From: Biazar, Shahab
Sent: Thursday, May 19, 2016 12:12 PM
To: 'CCEAlbq@aol.com'; acacarrillo@cabq.gov
Cc: rtmf91@gmail.com; Cherne, Curtis
Subject: RE: 9000 Alameda (John Jones) Certification

**Re: The Jones's Home
9000 Alameda Ave NE
Grading and Drainage
Engineers Stamp Date 9/2/2015 (C20D073)**

**Re: The Jones's Home
9000 Alameda Ave NE
Grading and Drainage
Engineers Stamp Date 8/20/2015 (C20D073)**

**Re: The Jones Home
9000 Alameda NE
Grading and Drainage
Engineers Stamp Date 7/22/2015 (C20D073)**

GRADING & DRAINAGE PLAN

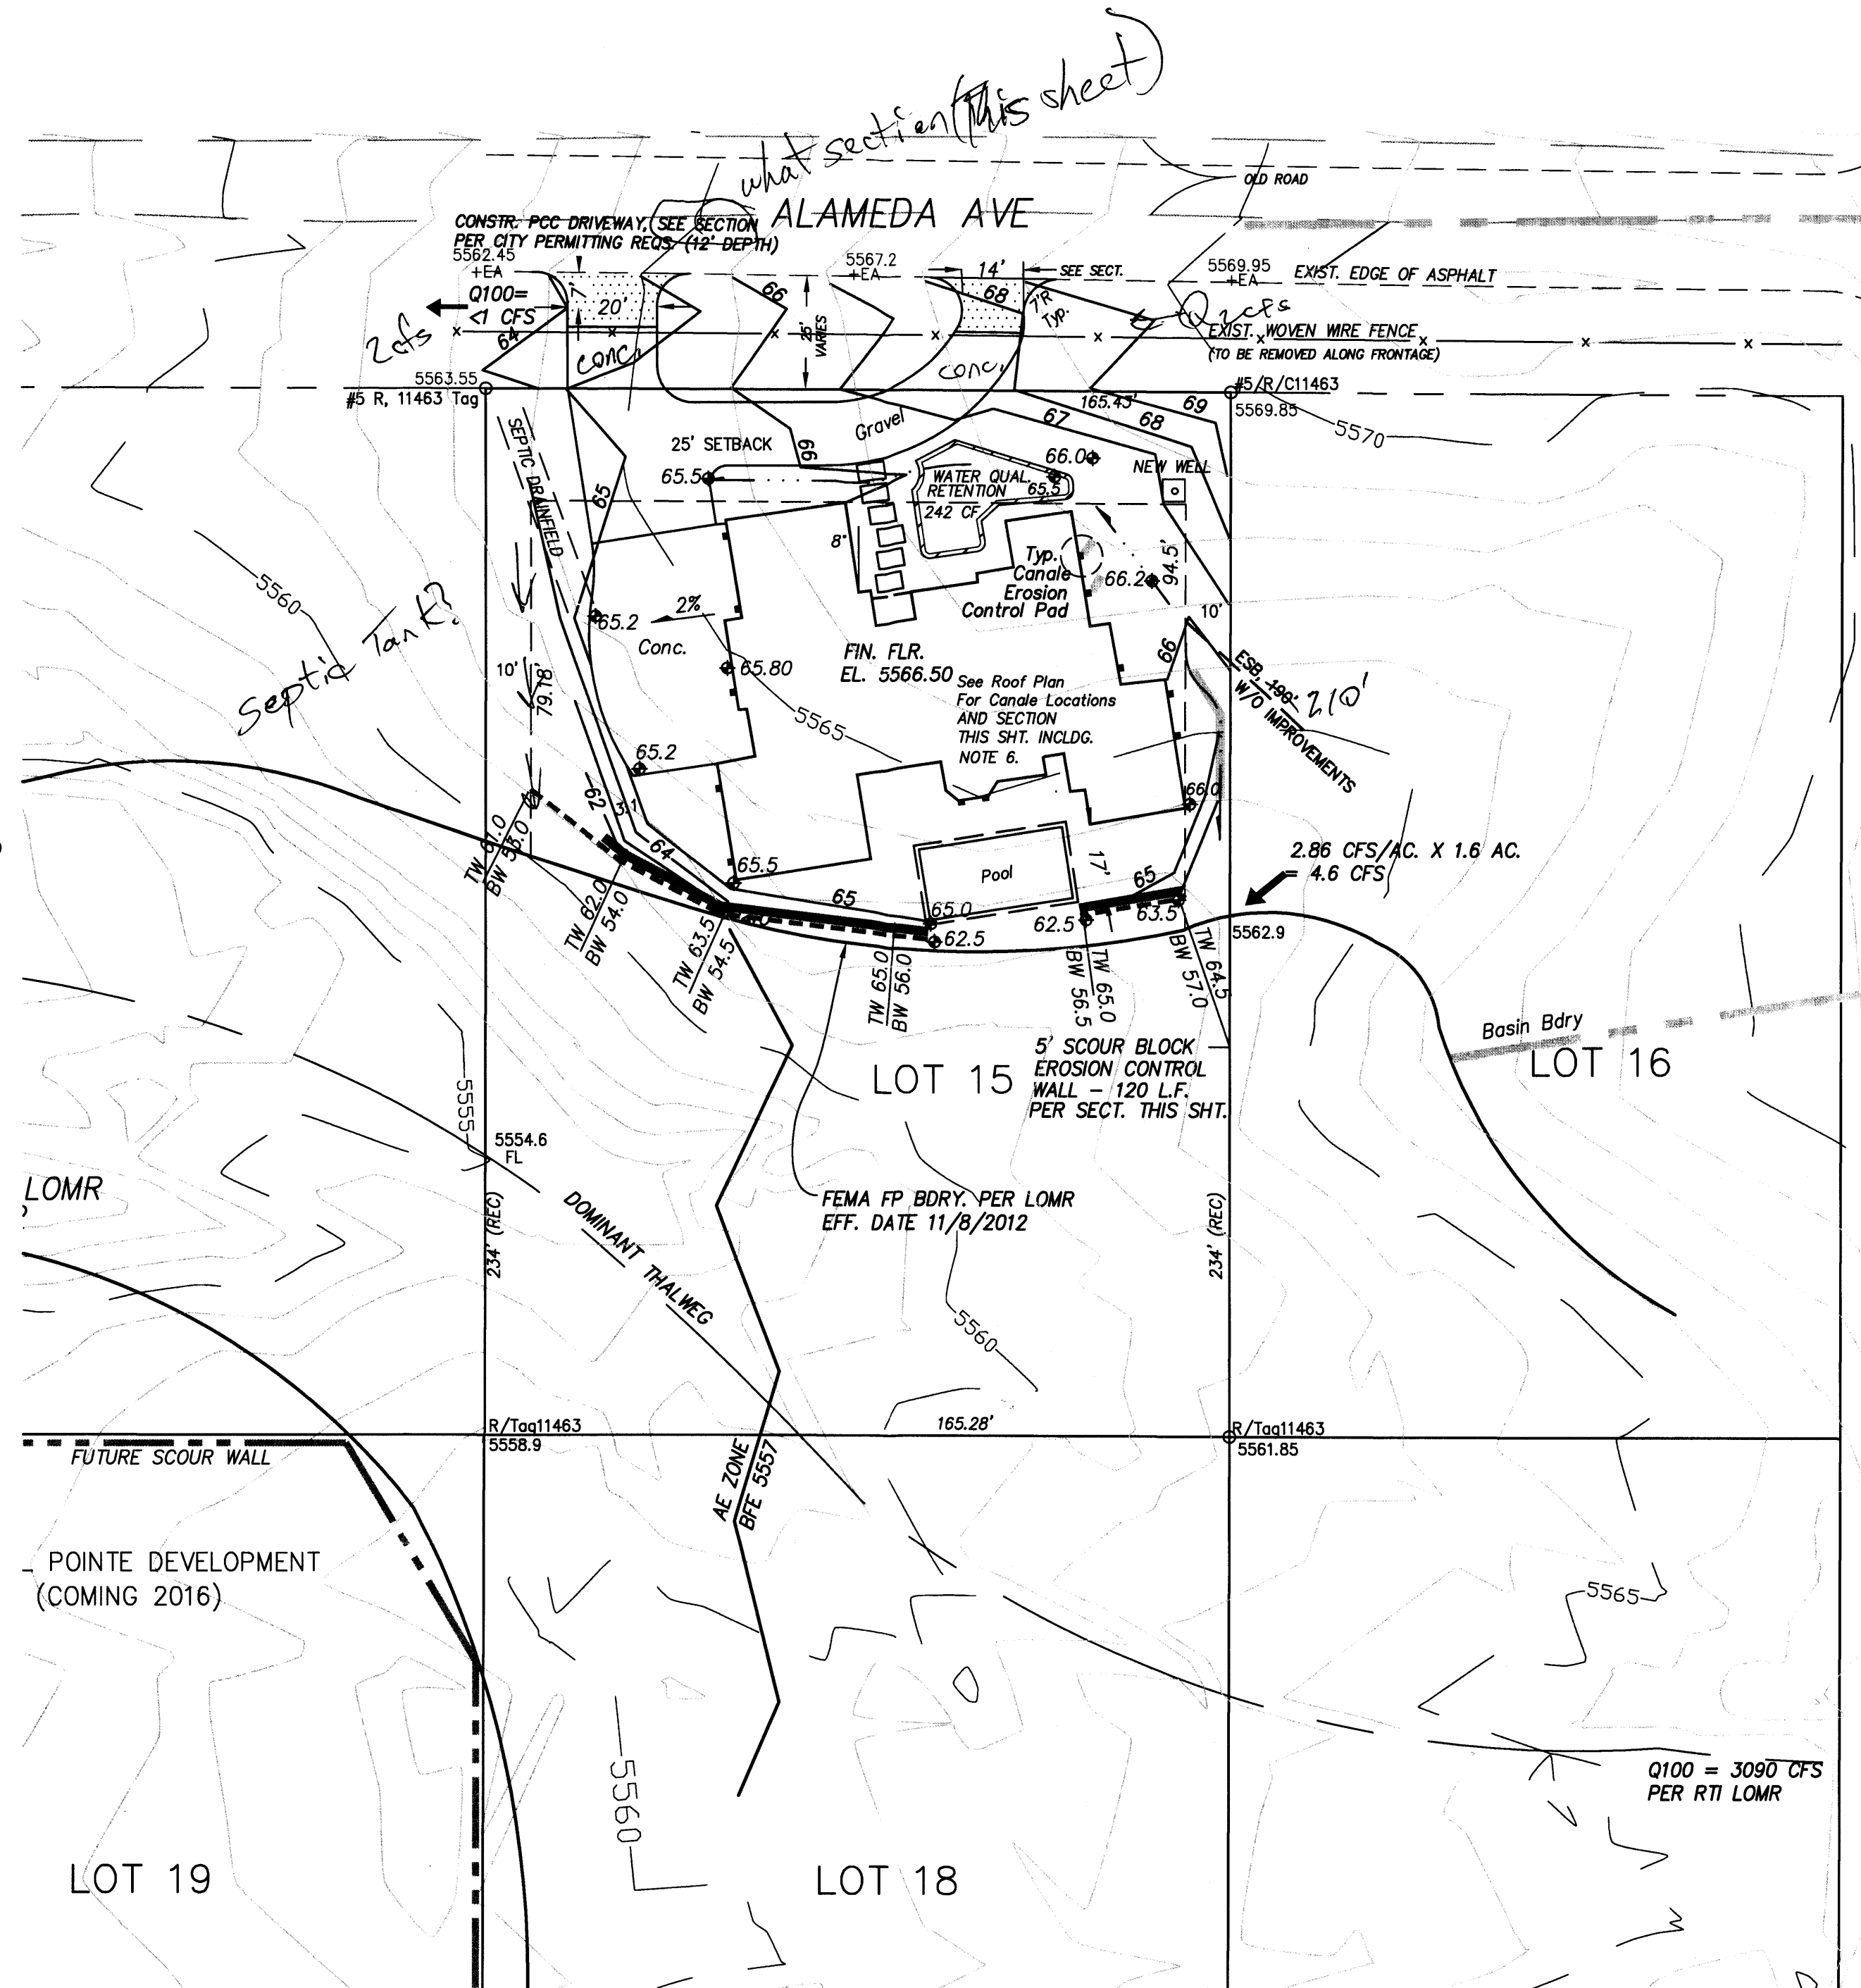
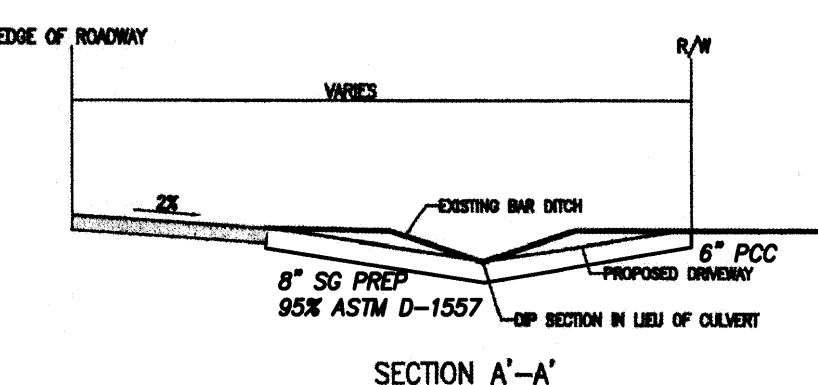
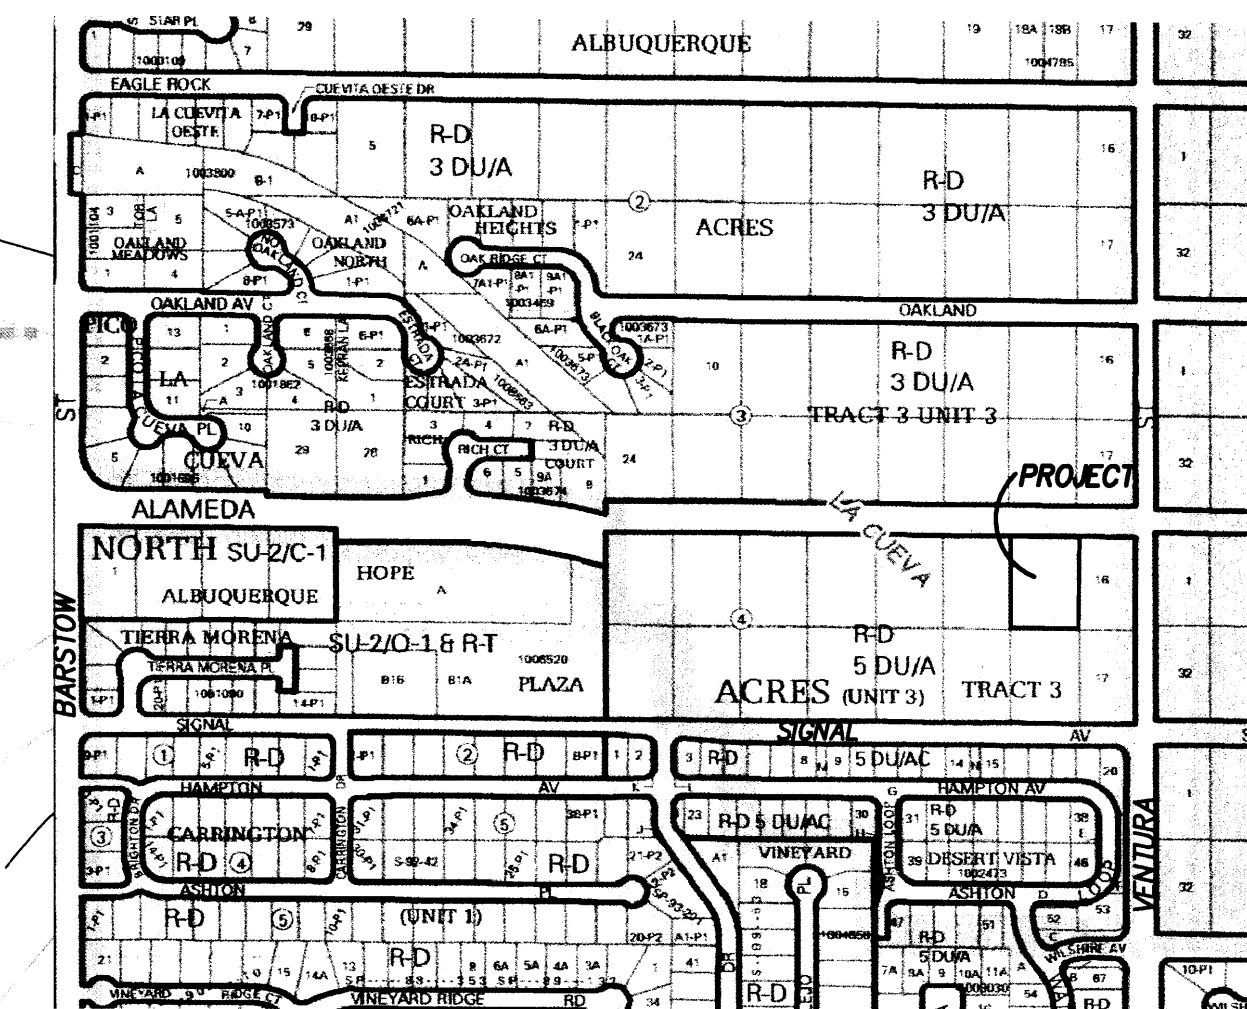
- Provide the location of the septic tank.
- Provide the specifications for the interlock retaining wall and scour wall system showing the tension fabric and other specifications.
- I calculated a Center Line Setback of 210', compared to your 190', please verify.
- Provide a concrete driveway up to the property line. Only one driveway is allowed off of Alameda.
- Provide reason for no scour wall to the south of the pool.
